Central Coast Quarter Stage 1 - 26-32 Mann Street, Gosford

Attachment A – Design Review Panel Advice

City of Gosford Design Advisory Panel*	
Panel meeting	30 March 2021
Panel members	Paulo Macchia, NSW Government Architect (Chair) Emily Goodworth, Central Coast Council – Panel Member John Choi, Design Reference Group Paul Walter, Design Reference Group Jared Phillips, Central Coast Council - Design Reference Group
Proposal name	Stage 1 DA Central Coast Quarter “St Hilliers”
Street Address/property description	26-32 Mann Street, Gosford Lot 469 DP 8211073, Lots 2-7 DP 14761, Lot 1 DP 1235203
Proposal description	Stage 1 DA Central Coast Quarter –Northern tower and through site link Mixed use development comprising residential and commercial/retail uses
Proposal details	IPC determination 24 August 2020 - Concept Approval <ul style="list-style-type: none"> • a building envelope including a podium and three towers, comprising: <ul style="list-style-type: none"> ○ maximum tower heights including: <ul style="list-style-type: none"> - Northern Tower up to RL 71.3m and RL 81.4m - Southern Tower up to RL 52.6m, RL 58.8m and RL 65.1m - Eastern Tower up to RL 71.3m ○ maximum of 39,244 m² GF

THROUGH SITE LINK LANDSCAPE PLAN

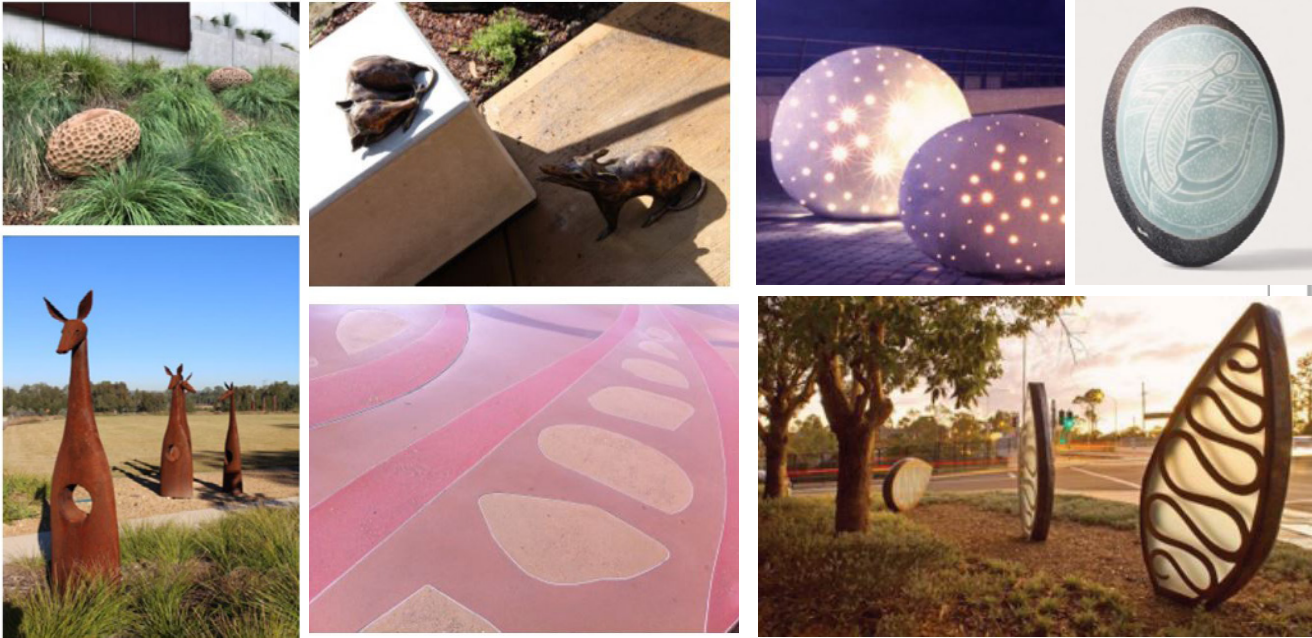
- The Stage 1 development plans are to incorporate the widening of the through site link (approx. 2m), as presented to the Panel;
 - The design team continues to explore opportunities to further integrate the development with the public domain interfaces with Baker Street. The design team liaise with Central Coast Council regarding its Streetscape Design Guidelines and other relevant Council Guidance; and
